**Section 96A of the Town & Country Planning Act 1990 (as amended)
Town and Country Planning (Development Management Procedure) (England) Order 2015
(as amended) - Article 10**

Non material amendment following R/233/20/HH for casement windows added to the north and south elevations of the approved extension.

2 Ruston Avenue Rustington BN16 2AP

DRAWING TITLE
Proposed Elevations

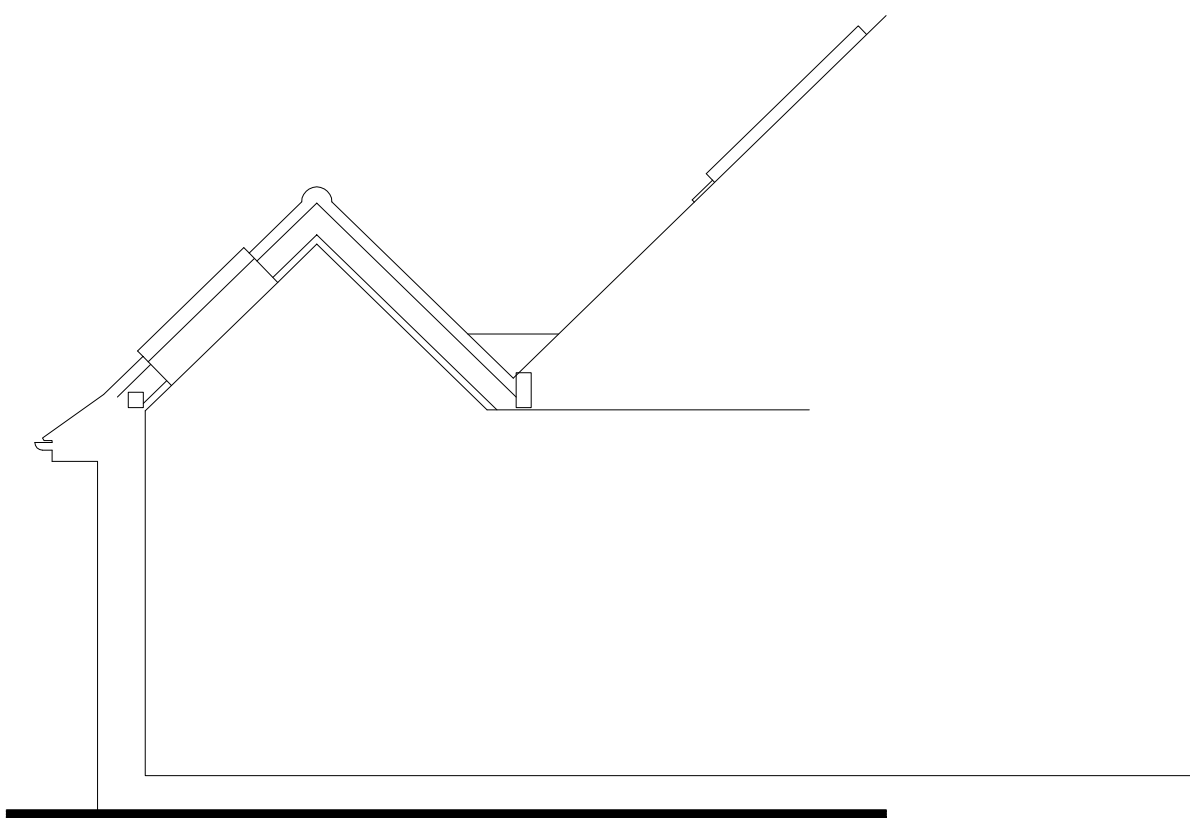
The reason that these proposals have been accepted as Non-Material Amendments is because it does not materially alter the appearance of the building and the proposed casement windows do not provide adverse impacts on neighbouring properties by way of overlooking. It can therefore be considered under section 96A of the Town and Country Planning Act 1990.

- Proposed Floor Plan Dwg No 20-110-5 Rev e
- Proposed Elevations Dwg No 20-110-6 Rev C
